From: [Ania Dorocinska](#)
To: [Nicole Boulton](#)
Subject: Request for clarification - Hazard assessment: SSD 9394
Date: Tuesday, 13 August 2019 3:18:00 PM
Importance: High

SSD 9394 / INTEGRATED POULTRY PROCESSING FACILITY

DPIE Hazard Assessment

Reference is made to the EIS for the Oakburn Poultry Processing Plant in Tamworth dated 2 July 2019 and undertaken by PSA Consulting Australia. To enable the Department's Hazards Team to finalise its review and assessment of the EIS, further detail and or clarification is required of the dangerous goods listed throughout the EIS:

Ref. No: 17426-CAL Sheet No: 100 of 06 Revision: F © Bath Stewart Associates Pty Ltd

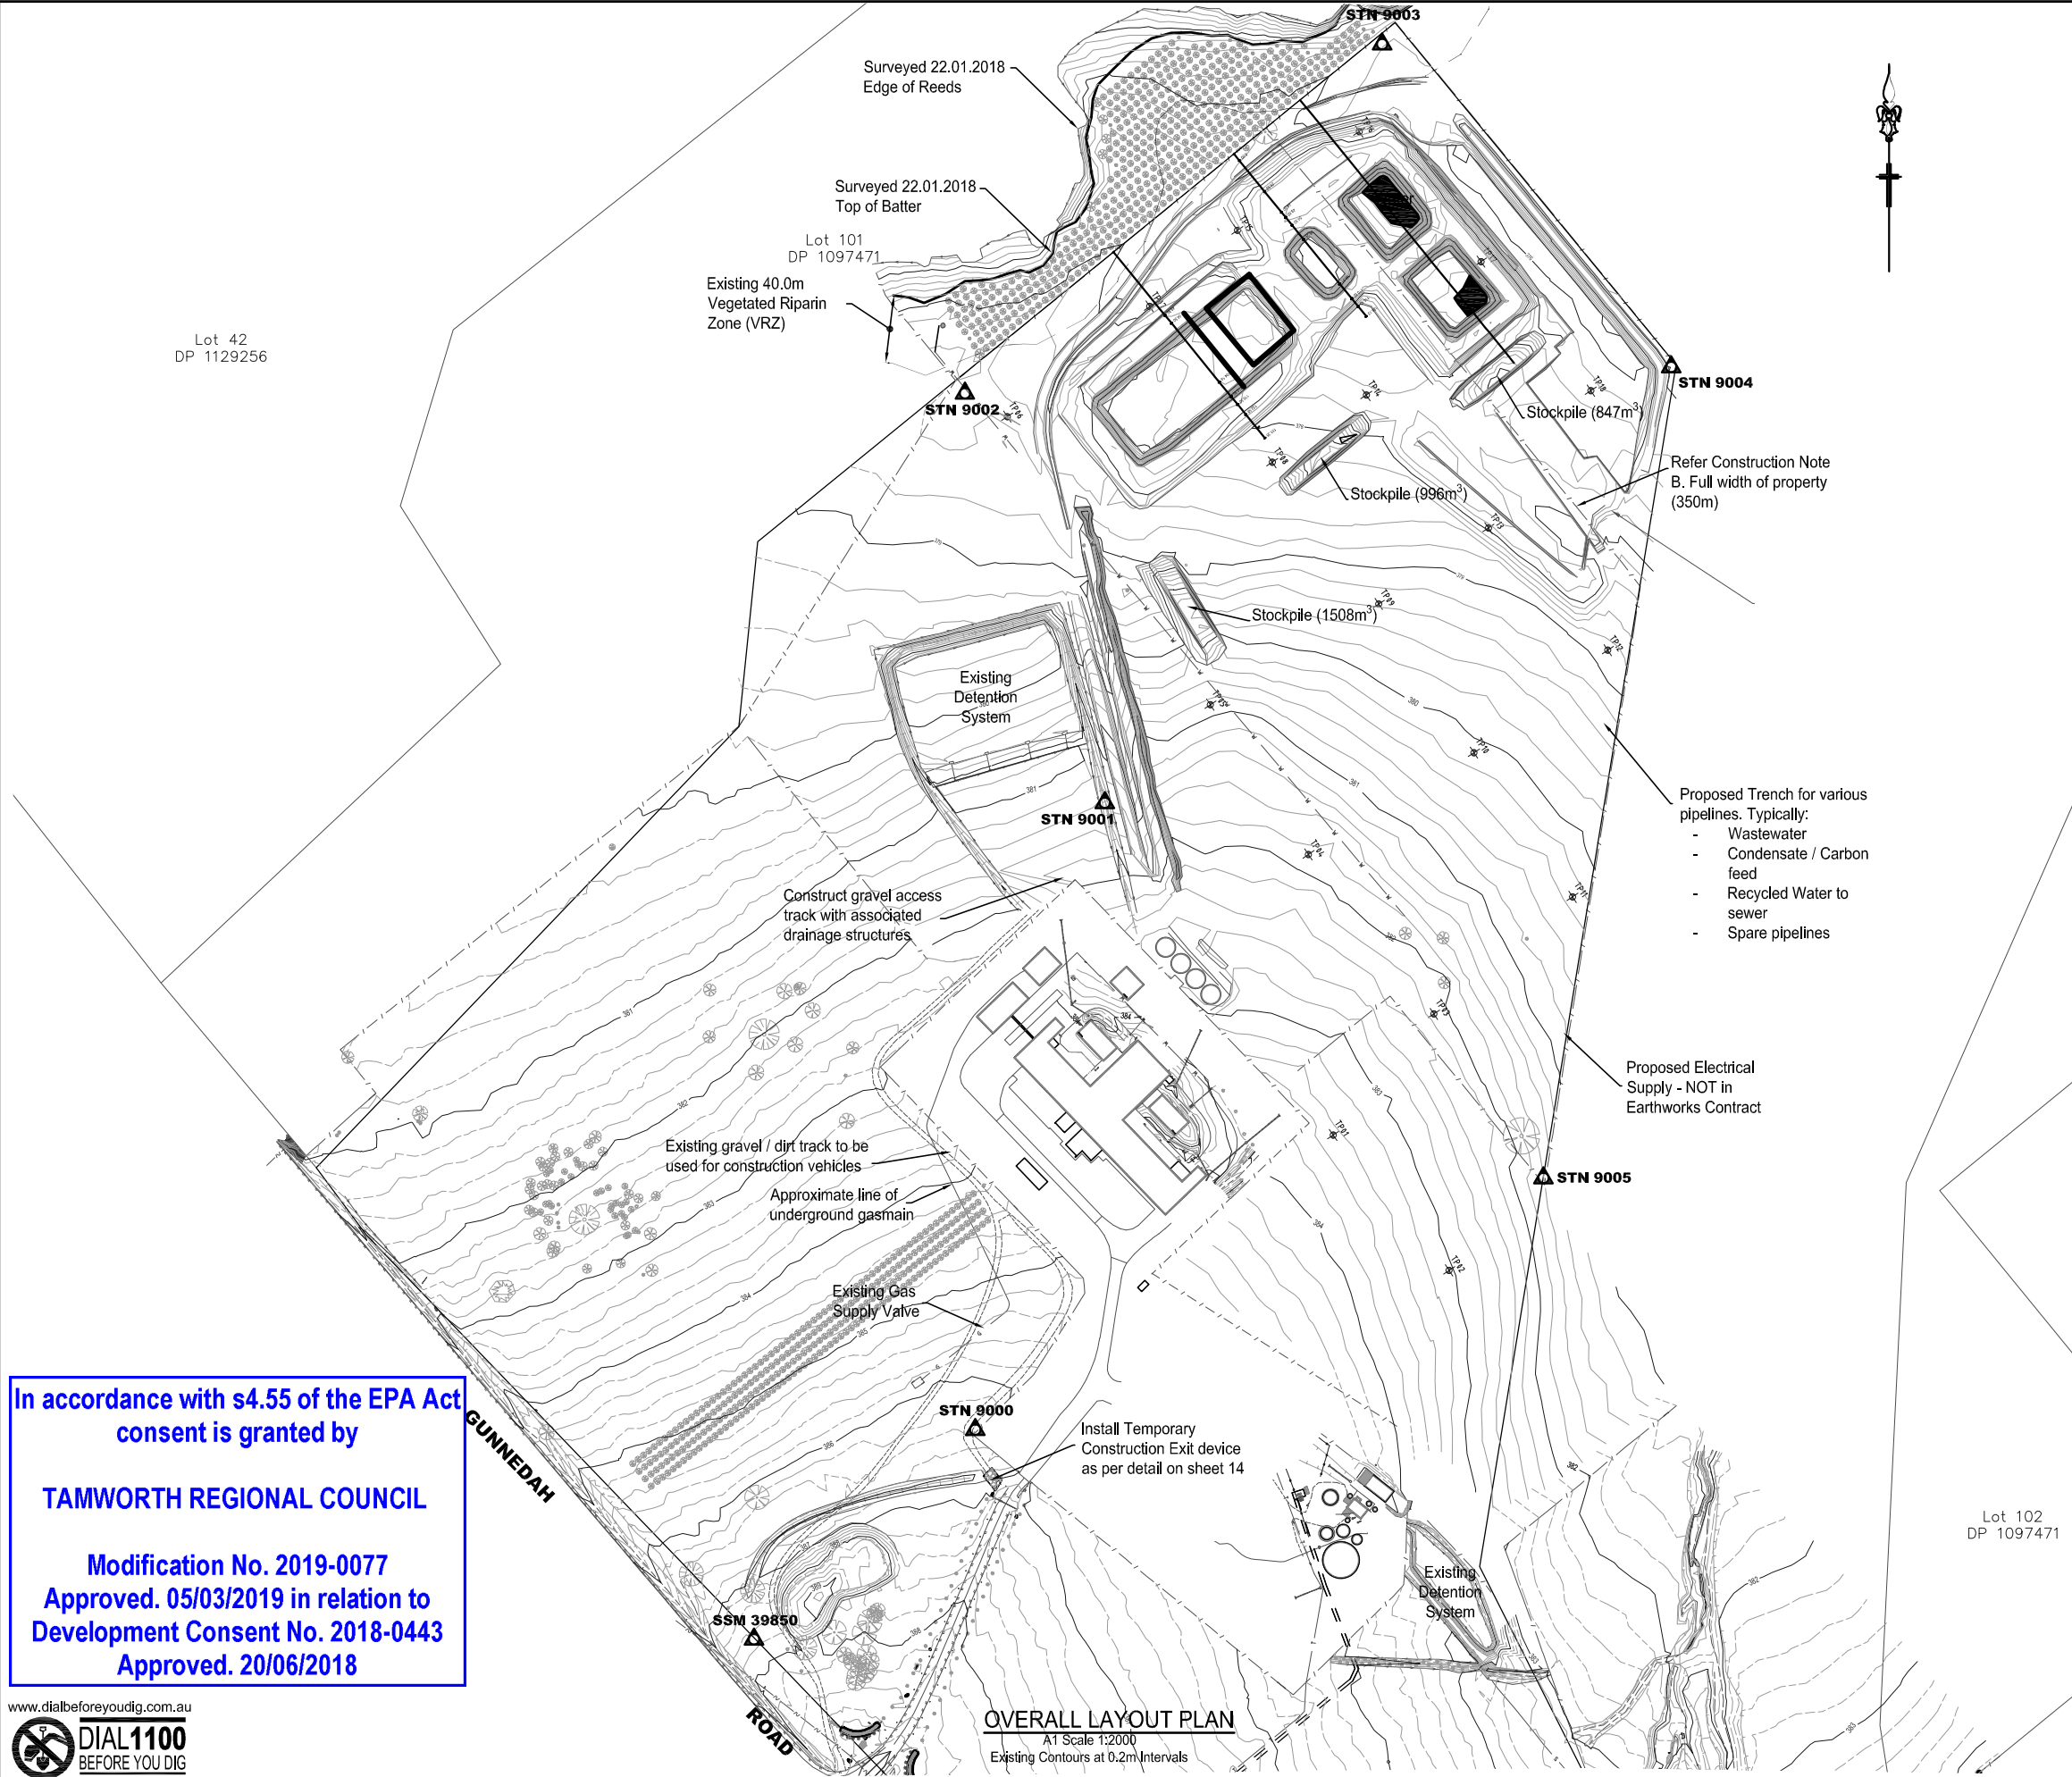
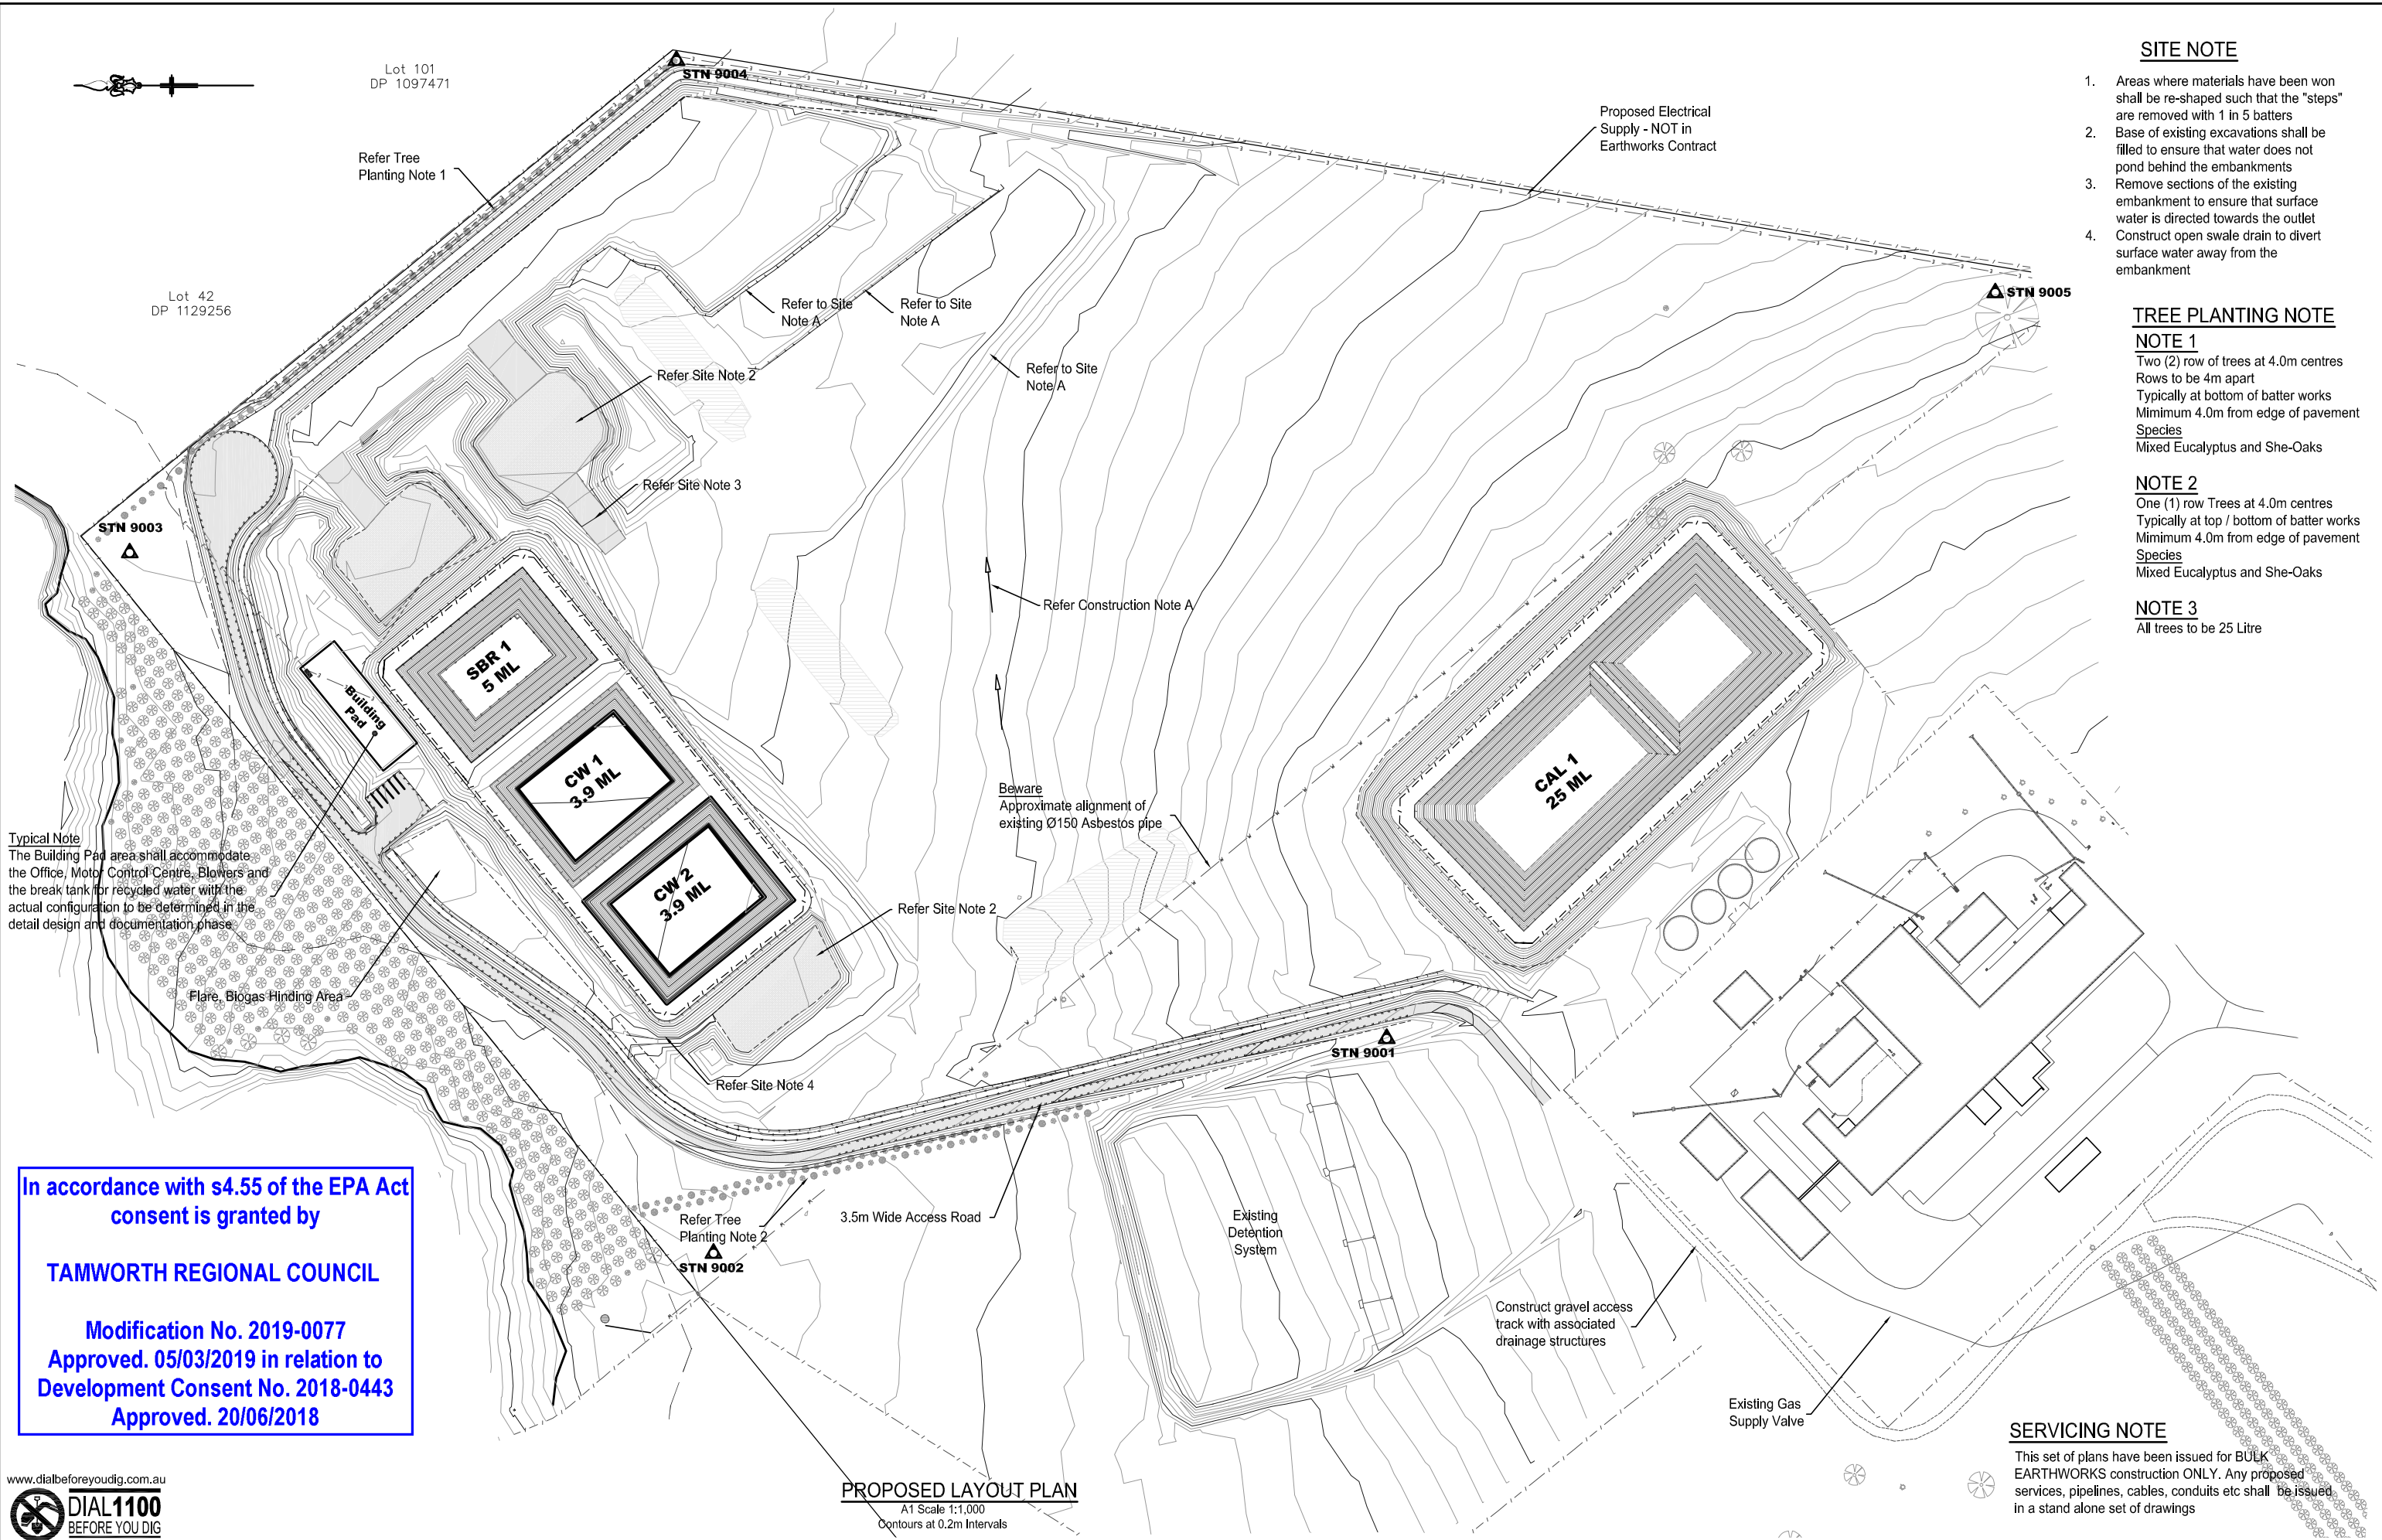
4. Is the new processing plant to be built over an existing Gas Supply Valve and underground gas main, refer to approved 20/06/2018 Tamworth Regional Council drawing number 17426-CAL Rev 7 for the Baiada Oakburn Rendering Plant? If not please indicate relocation of gas line and gas supply valve.
